SWPPP COMPLIANCE INSPECTION REPORT

Date of Inspection	Thursday, December 5, 2019
Project	Coors Village Offsite
Location	Western Trails and Coors Blvd

NPDES #	NMR10022T/NMR10022M
Permit Type	Construction General Permit
Inspection Type	14 day SWPPP Compliance Inspection

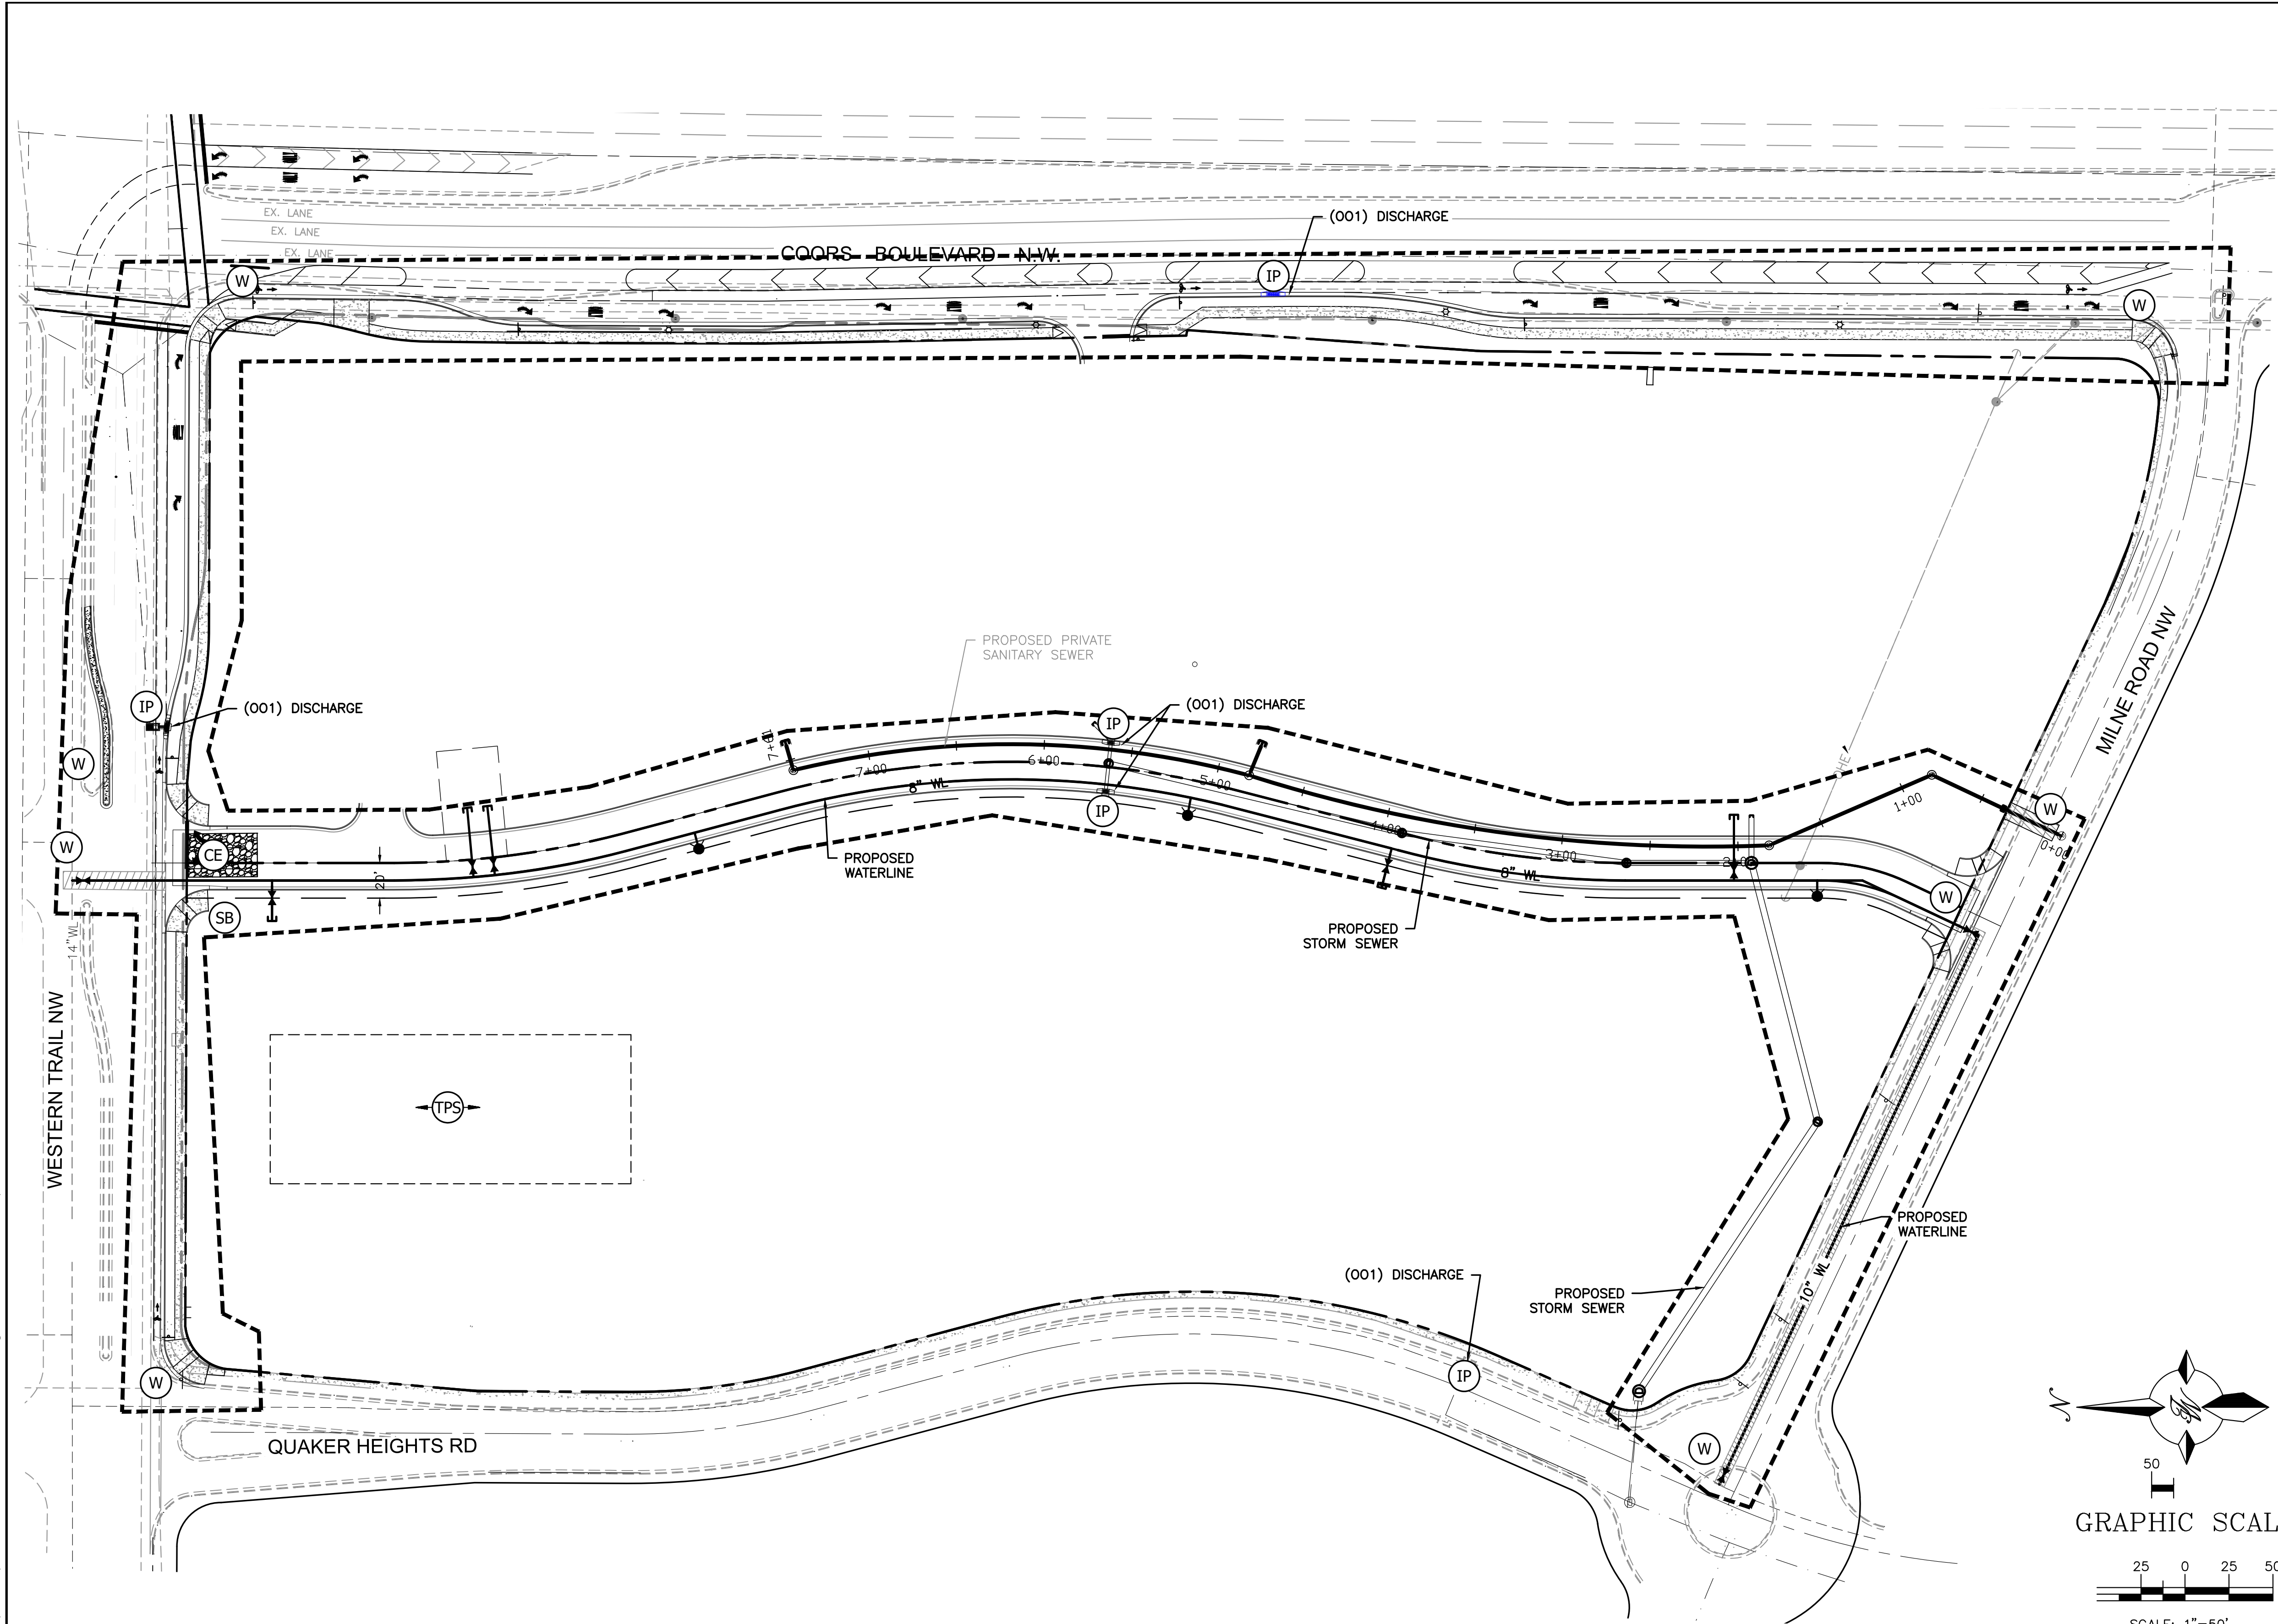
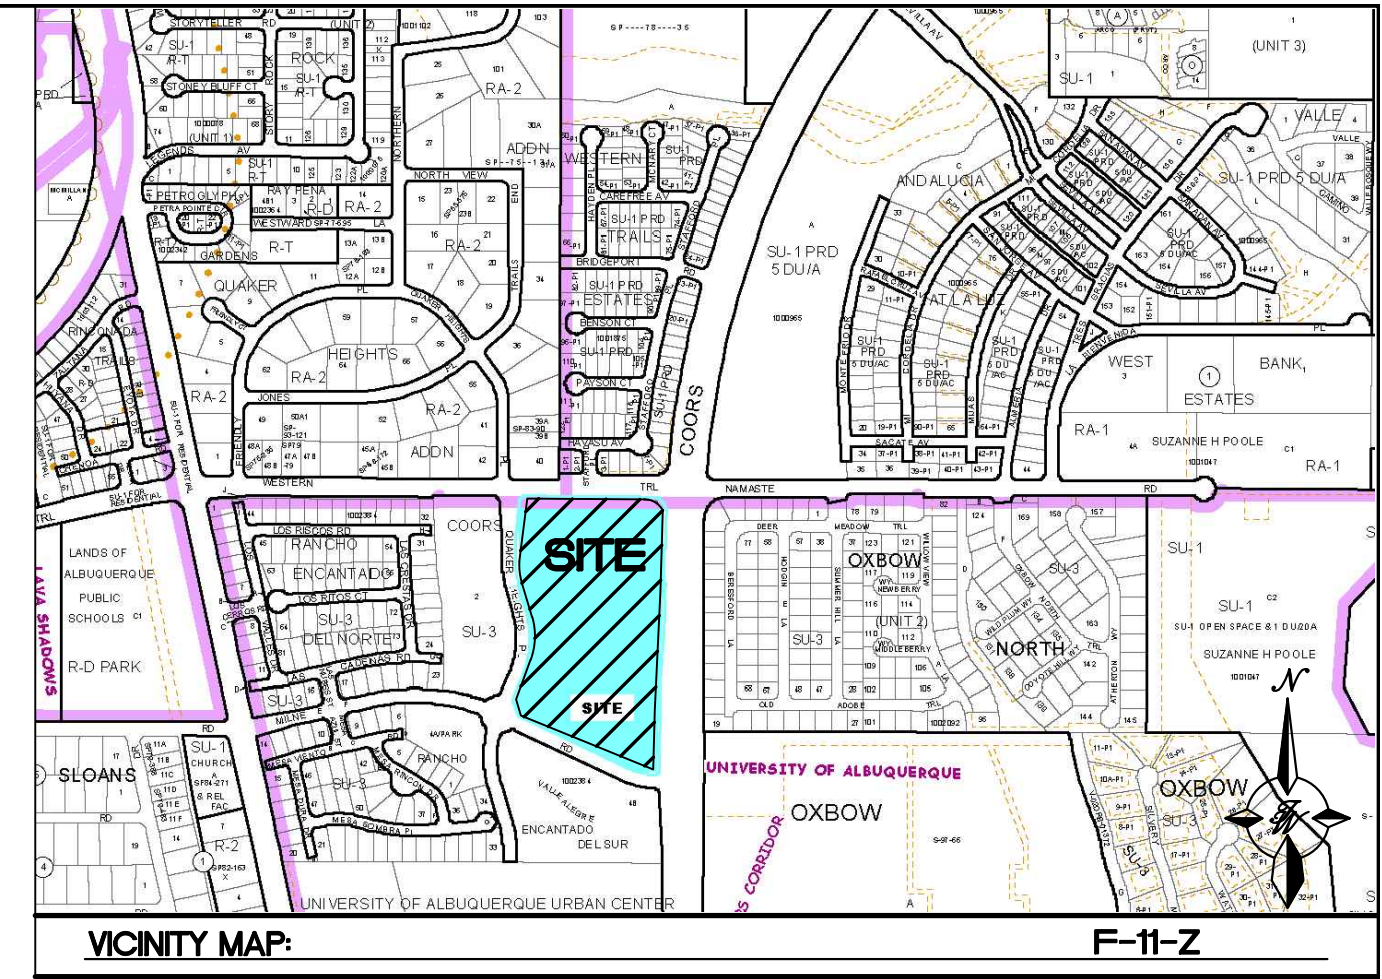
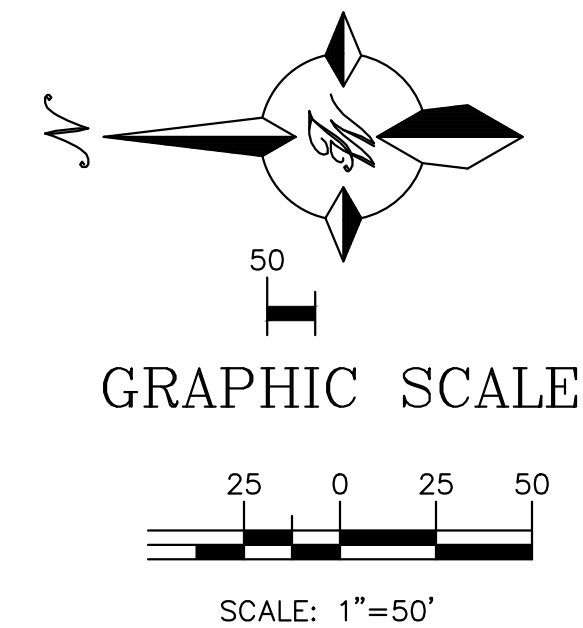
Is there Evidence of a Discharge Since Last Inspection?			Yes
Was a discharge observed in progress?			No
Location:	Internal Roadway		
Discharge Description :	Inlets along internal roadway are still unprotected and are being infiltrated by sediment

POLLUTION PREVENTION, SEDIMENT AND EROSION CONTROLS			
List Any BMP's Or Controls That Require Maintenance or Corrective Actions?			
Control	Location	Issue	Maintenance or Corrective Action?
Entrances/ exits	All access points	Track out	Sweep clean daily
Wattles	Quaker Heights	Flattened	Replace
Silt Fence	South of private roadway	Displaced, sagging, not functioning	Re-set
Permanent Stabilization is now required of all disturbed areas

Sweep sediment that is escaping the limits of construction through construction entrance back into the property at the end of each day.

Provide inlet protection for curb inlets on internal roadway.
